TEMPORARY CONSTRUCTION ACCESS, FORD LANE, YAPTON, WEST SUSSEX

DESIGNER'S RESPONSE TO ROAD SAFETY AUDIT STAGE 1/2

Project: 18-344

Report No.: 18-344-18

Scale 1:200 @A1	Date AUG 20	Designed
Drawn JA	Checked SG	Approved LH
Job No 18-344	Drawing No 18-344/703	Rev B

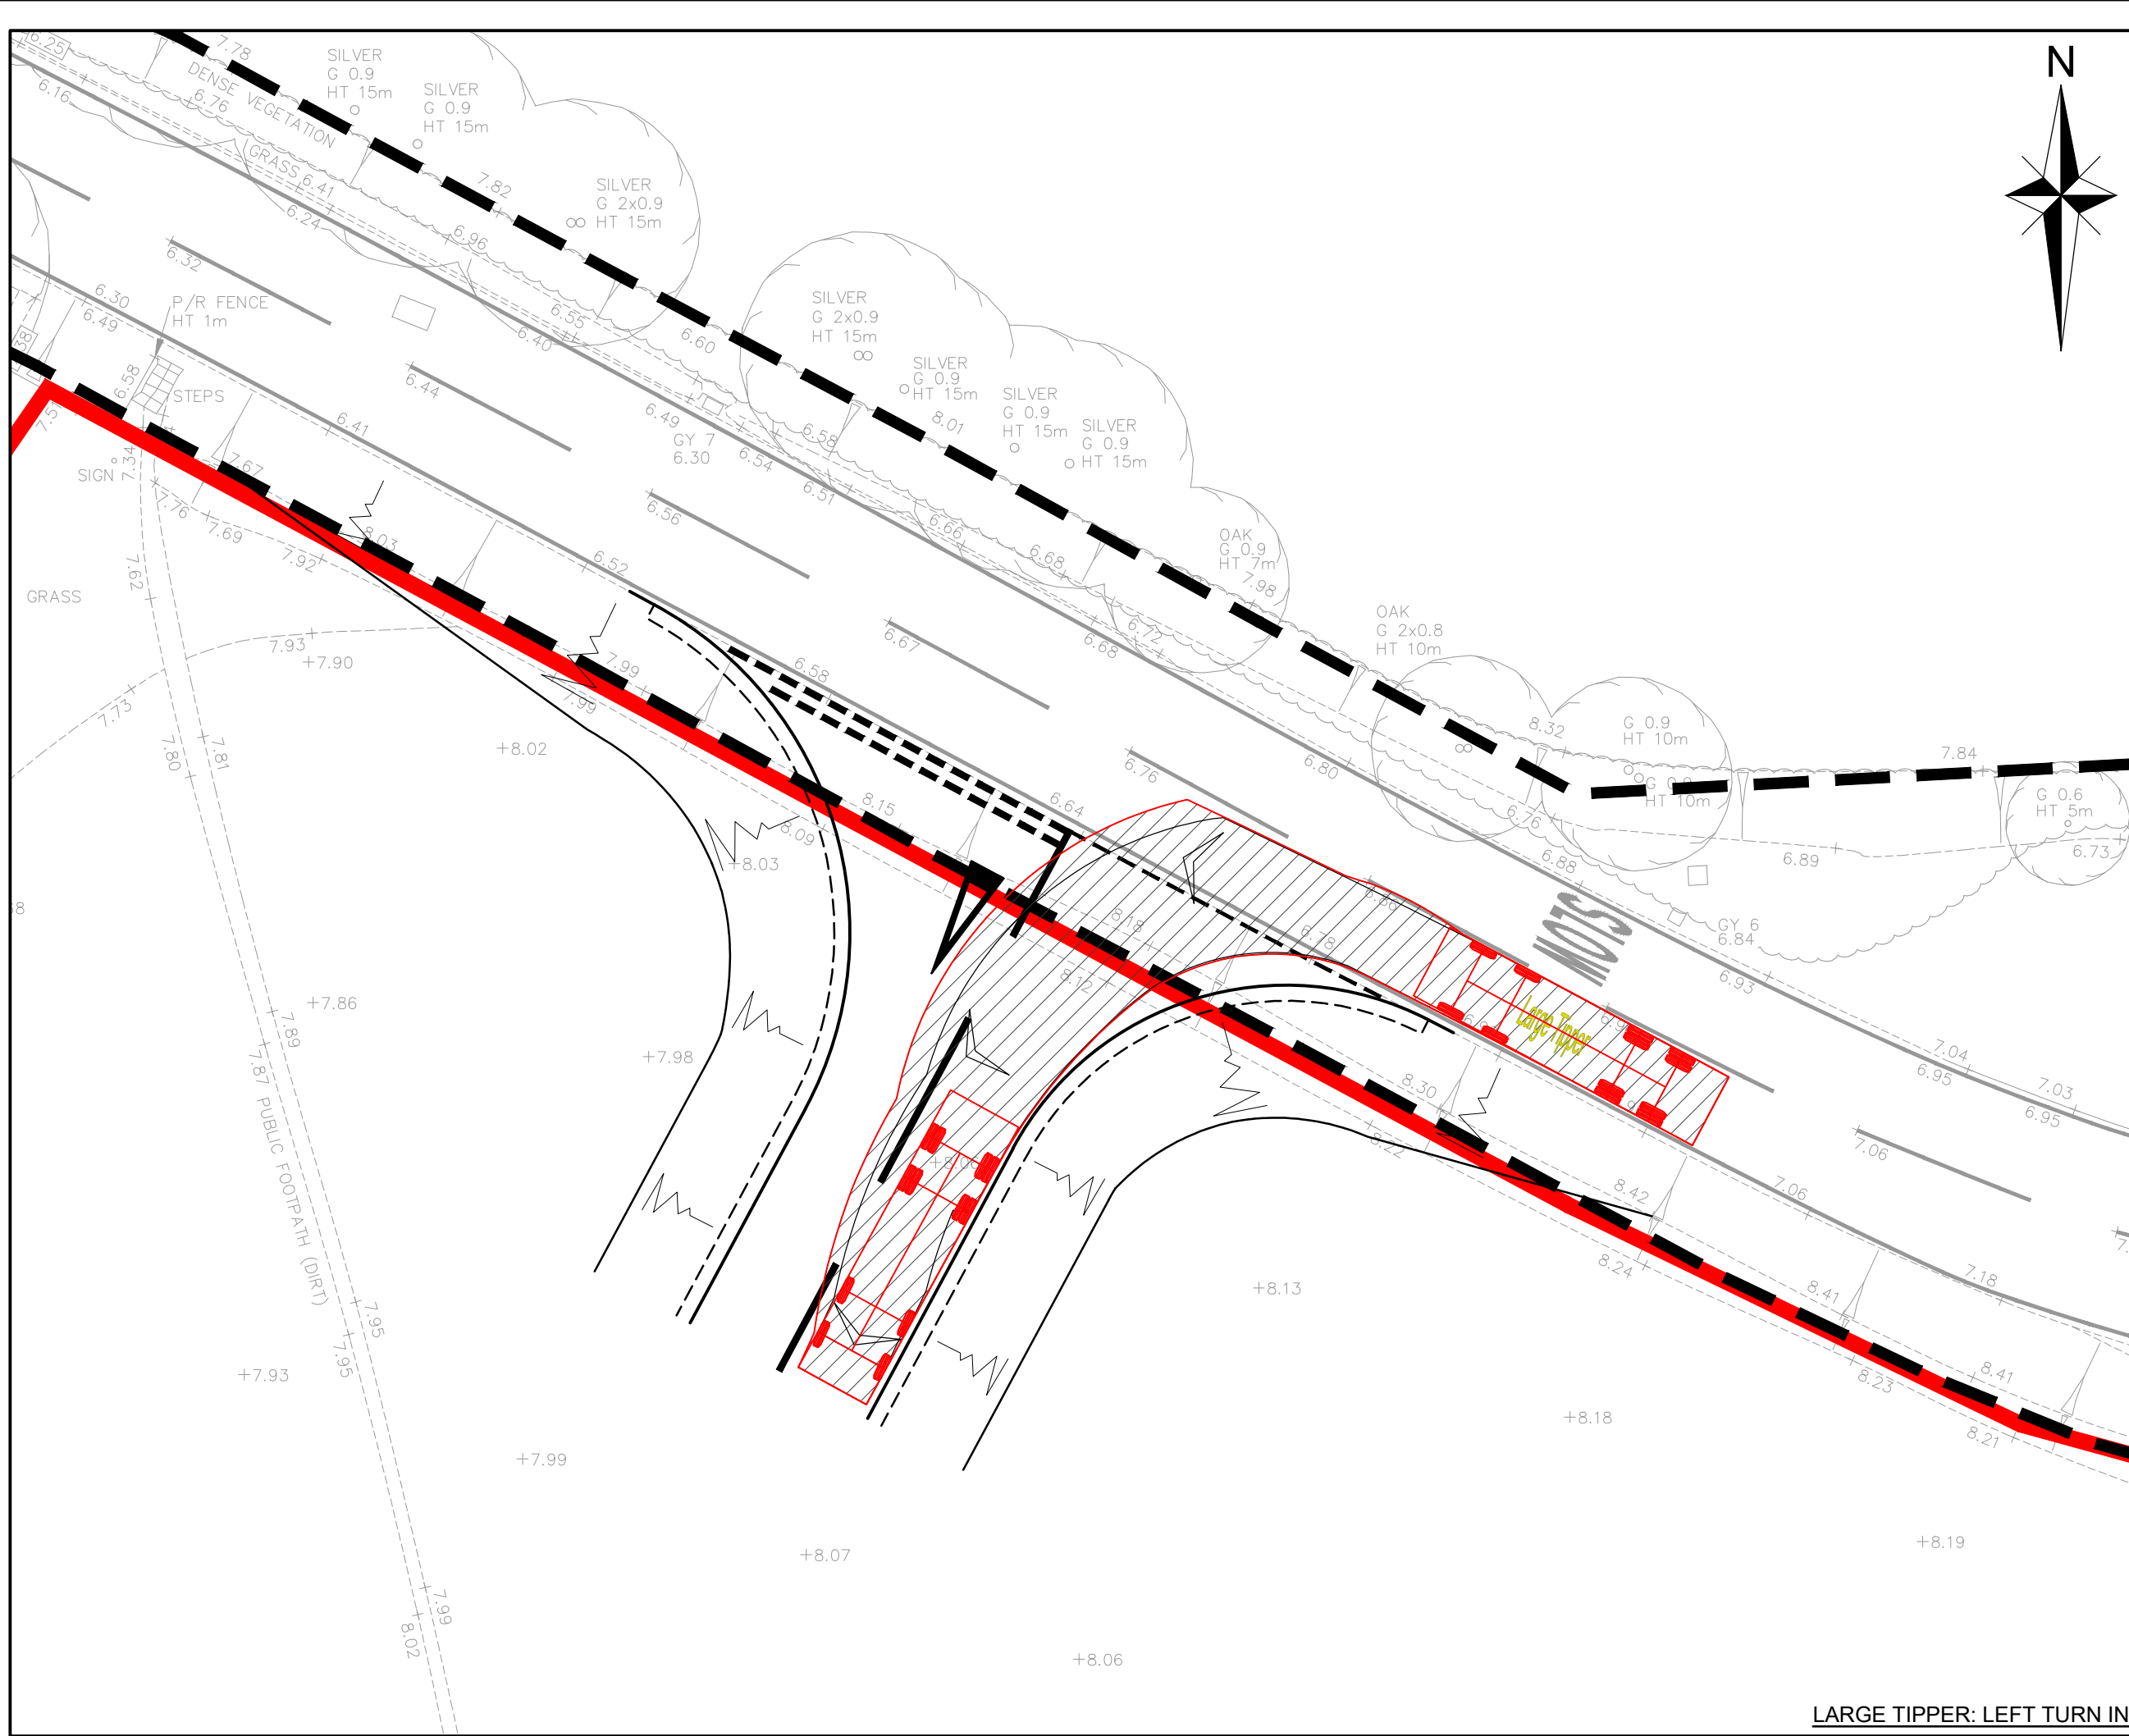
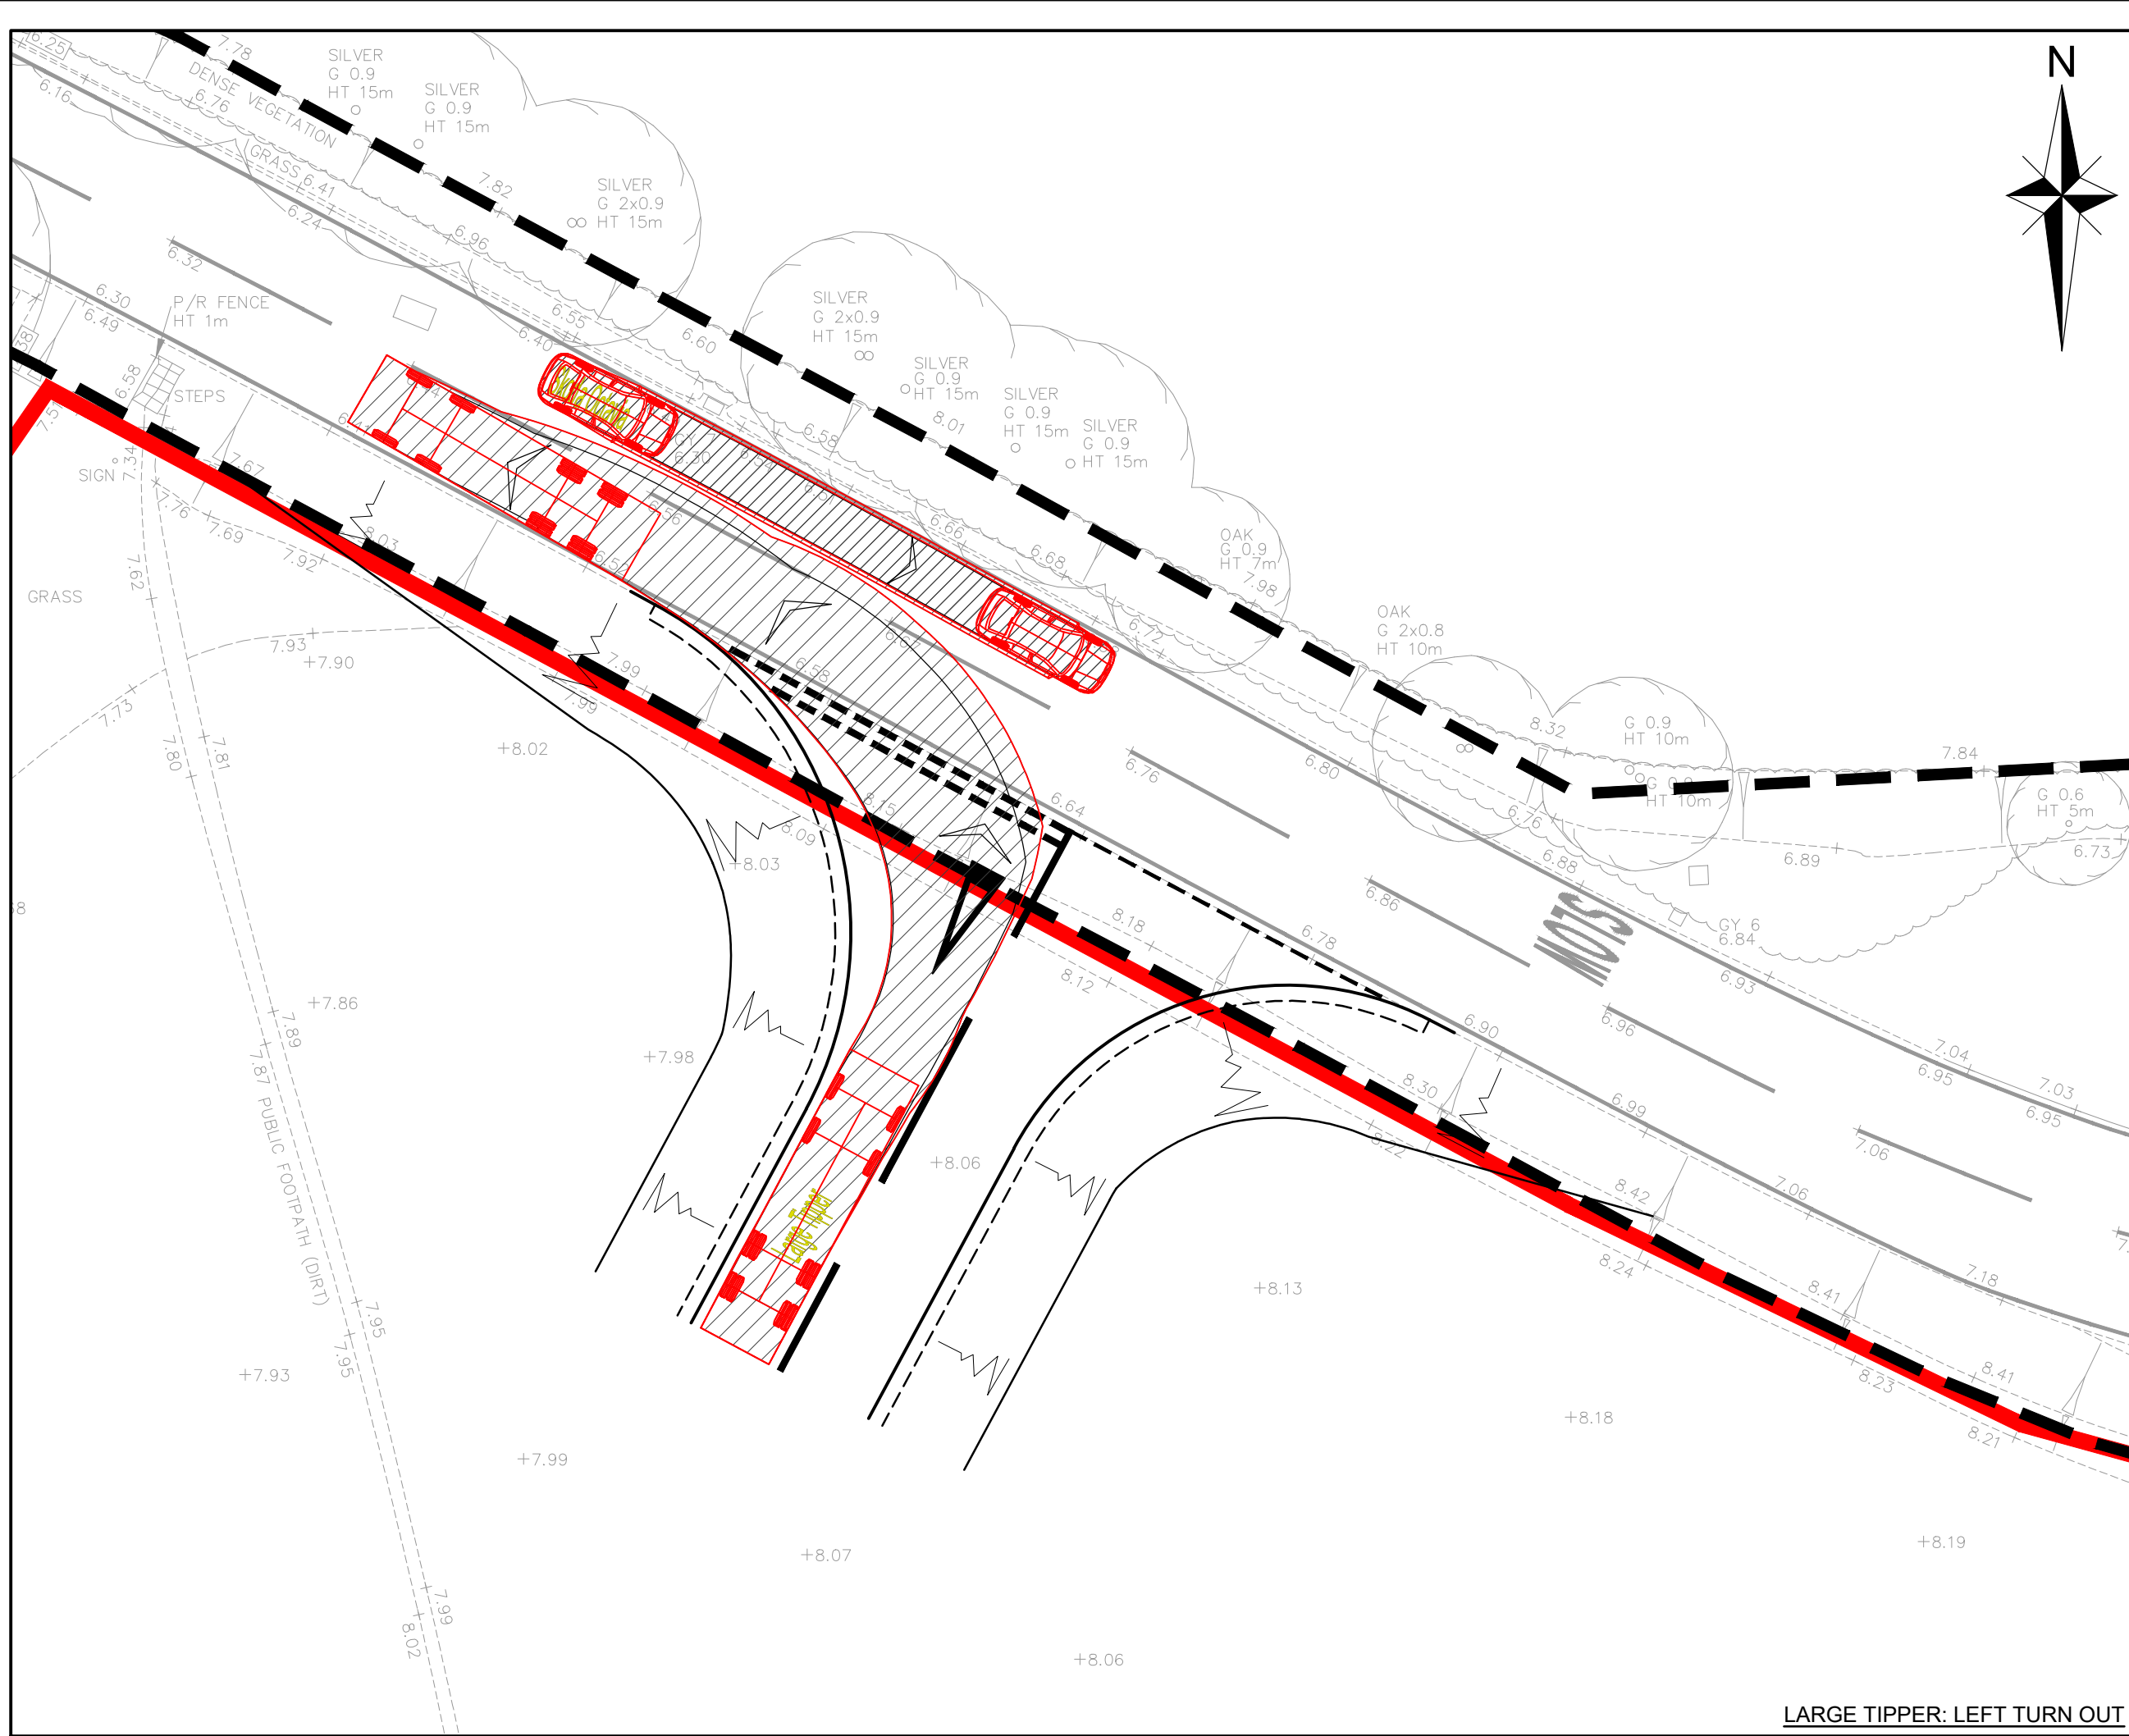
Audit Item No.	Audit Team Observation	Audit Team Recommendation	Odyssey Designer's Response	Client Comment
	Summary: Insufficient carriageway space could lead to rear end shunt head on or side impact collisions. The proposed temporary access is shown as being 5.5m in width and has a 6m radius on the south eastern side of the junction. Swept paths provided show marked deviations in paths taken to make the turns into and out of the temporary access., which could lead to head on collisions. There is concern that at 5.5m in width with the current radii that two-way HGV operation of the access will not be possible. This could lead to vehicles stopping or reversing onto Ford Lane, which could lead to rear end shunt head on or side impact collisions.	It is recommended that the temporary access and associated radii should be capable of accommodating simultaneous two-way HGV movements.	The junction layout is typical for this type of access/use. Provision of a layout to simultaneously accommodate two HVGs would make the access unnecessarily oversized and could lead to increased vehicle entry/exit speeds.
